**Town & Country Planning Act 1990 (as amended)
Town and Country Planning (Development Management Procedure) (England) Order 2010 (as amended)
Application for Full Planning Permission**

Development Raise the height of the existing acoustic fencing along the southern boundary by an additional 1m to a total height of 3m. This application also falls within the parish of Barnham.

Location Toddington Nurseries, Lake Lane Nursery Park Road Barnham

Site Location

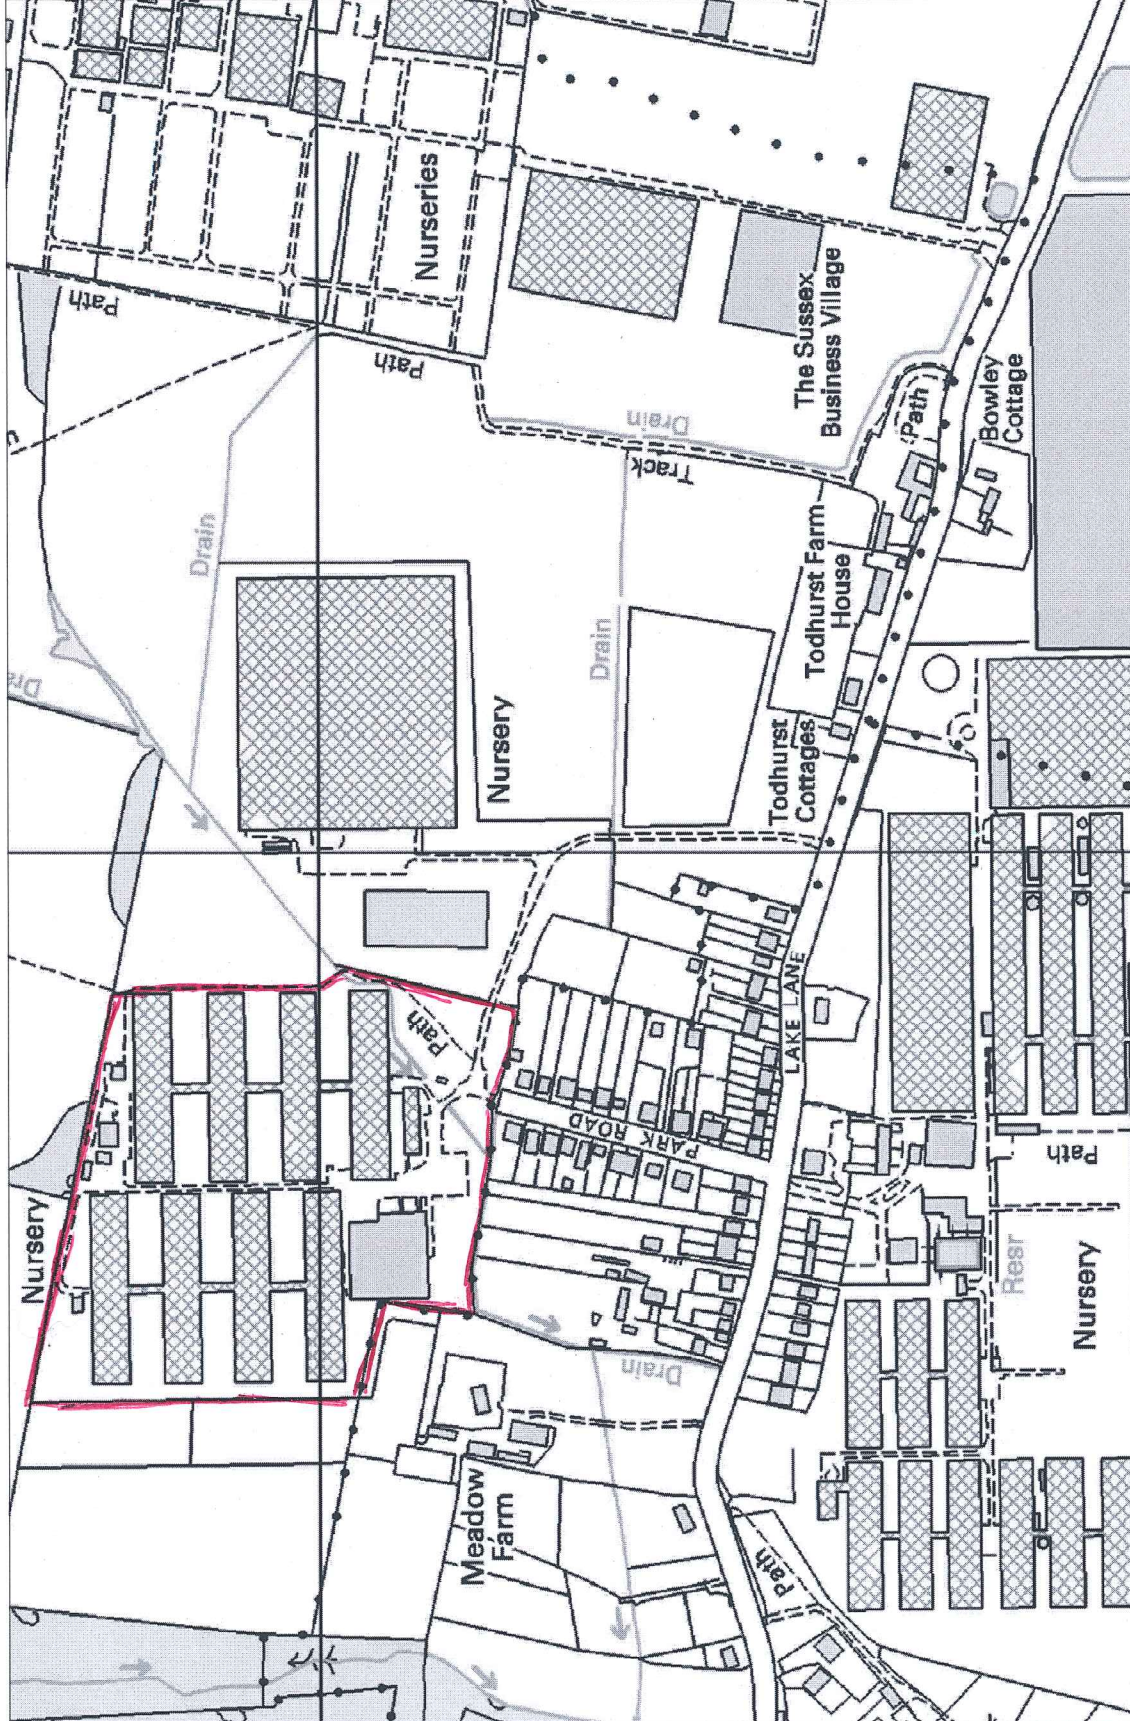
I require 1 electronic or 3 paper copies of an amended Location plan to include a red edged site (to accord with the site plan) in accordance with the guidance notes available on our website detailed below (click on National List).
